# CITY OF ALBUQUERQUE

RE: **Lot 1 Block 9 SAD 228**  
**6601 Petirrojo NW**  
**Volcano Cliffs Subdivision**  
**Grading and Drainage Plan**  
**Engineers Stamp Date 5/30/19 (D10D003I1)**

Based upon the information provided in your submittal received 6/11/19, this plan cannot be approved for Grading Permit until the following comments are addressed.

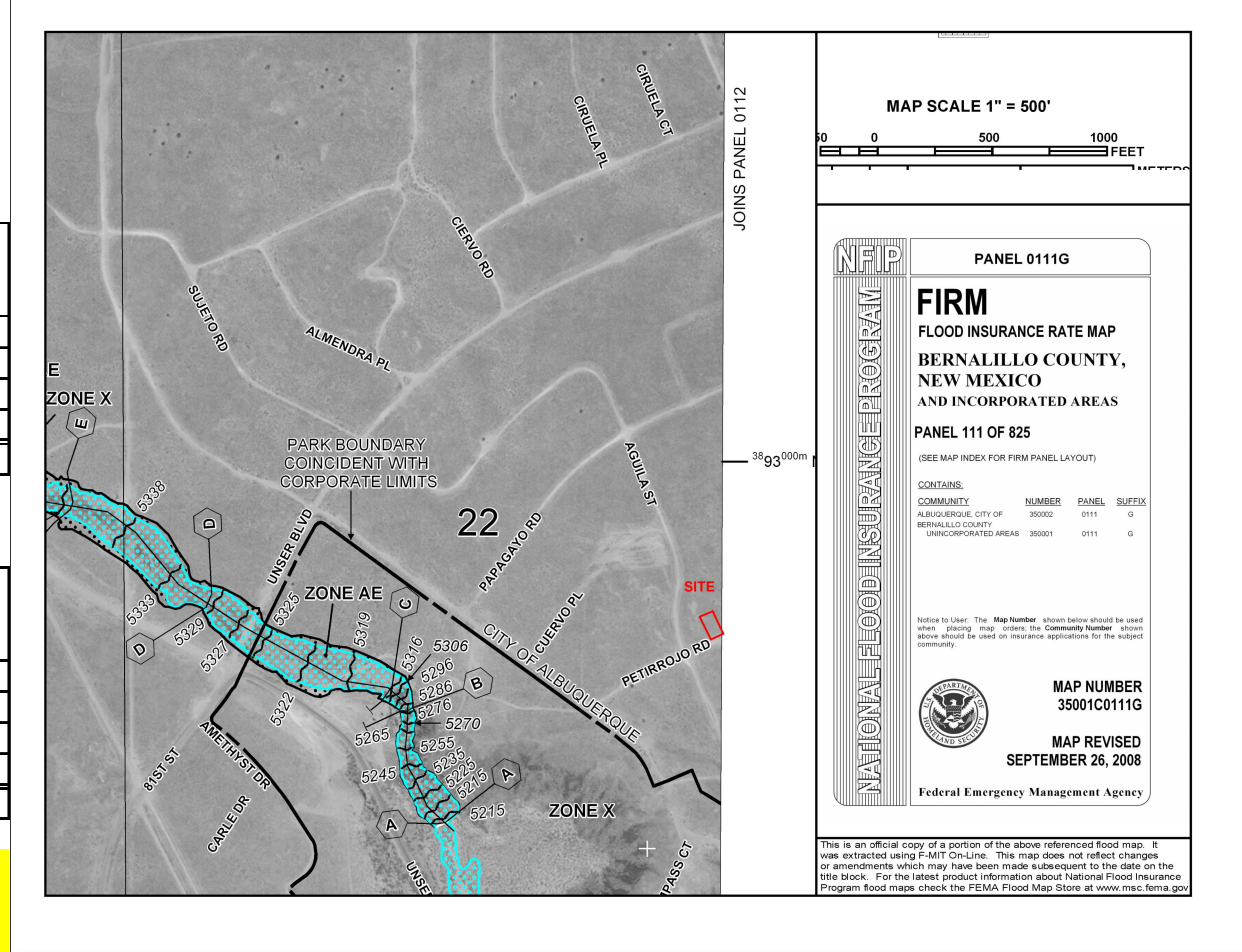
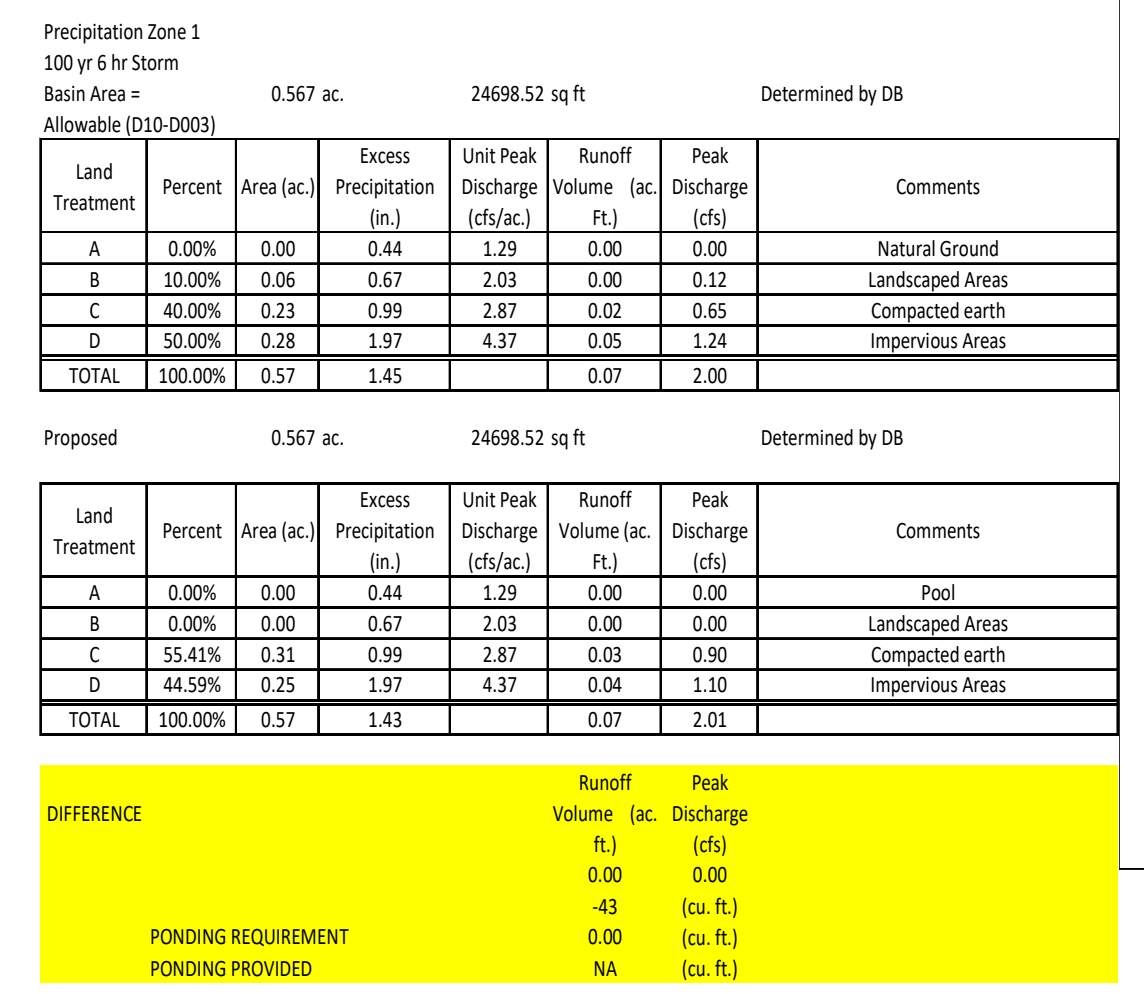
- Provide a cross section of the New CMU wall. Show the CMU wall and the orientation with the property line. If footing protrudes into adjacent property provide a letter of approval from the property owner that allows digging on their property or show that the footing will remain solely on said property.

1. Show the 7' PUE in the east side yard. *This has been added to the plan.*
2. Provide a cross section of the new CMU wall. Show the CMU wall and the orientation with the property line. If footing protrudes into the adjacent property, provide a letter of approval from the property owner that allows digging on their property. *A cross section has been provided. The wall is proposed to be located 1' off the property line. Any disturbance on the adjacent property will be re-seeded.*
